LONDON LUTON AIRPORT EXPANSION – DEADLINE 11 SUBMISSION

**Final Submission from National Highways Limited (Deadline 11) on outstanding matters related to the SRN
Application by London Luton Airport Limited for an Order granting Development Consent for the proposed London Luton
Airport Expansion Project**

Planning Inspectorate Reference Number: TR020001

Figure 2 - Figure 3.30d Layout B intervention 2 - Two-lane auxiliary diverge described in DMRB CD 122

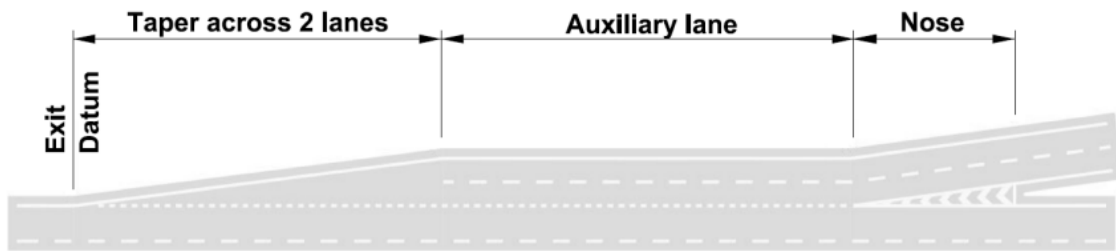
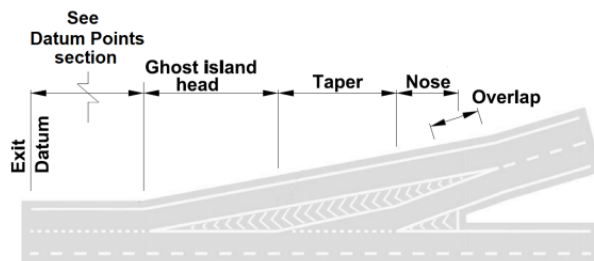
(4) Any scheme of works to the northbound merge must include changing the diverge layout type from ‘Layout B option 2 – Two-lane auxiliary diverge’ to a higher capacity ‘Layout B option 1 – ghost island lane drop’ which would be facilitated by an extension of the 4th lane from the lane-drop location to the north of M1 Junction 9 to form a new lane-drop at the Junction 10 diverge, or any alternative scheme approved by National Highways.

Figure 8 - An extract from the intervention's drawing M1_J10_SB_Mer_Op2

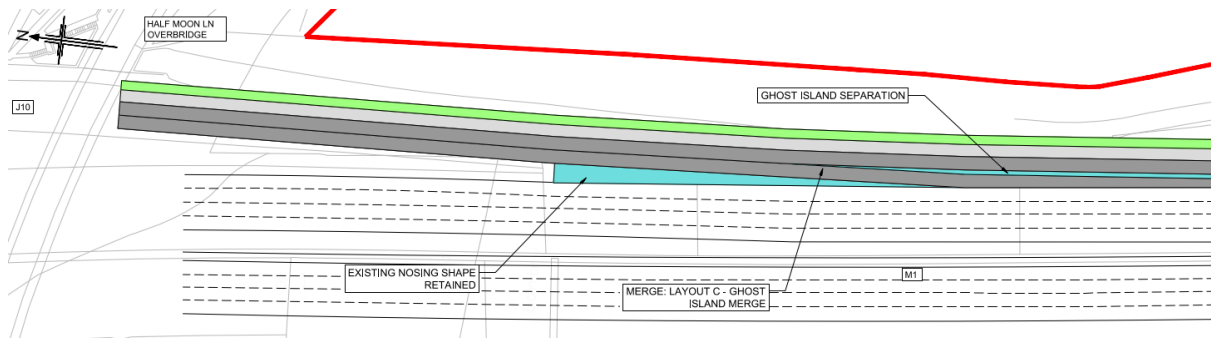
(3) Any scheme of works to the southbound merge must include changing the merge layout type from ‘Layout B – parallel merge’ to a higher capacity ‘Layout C – ghost island merge’ or any alternative scheme approved by National Highways.
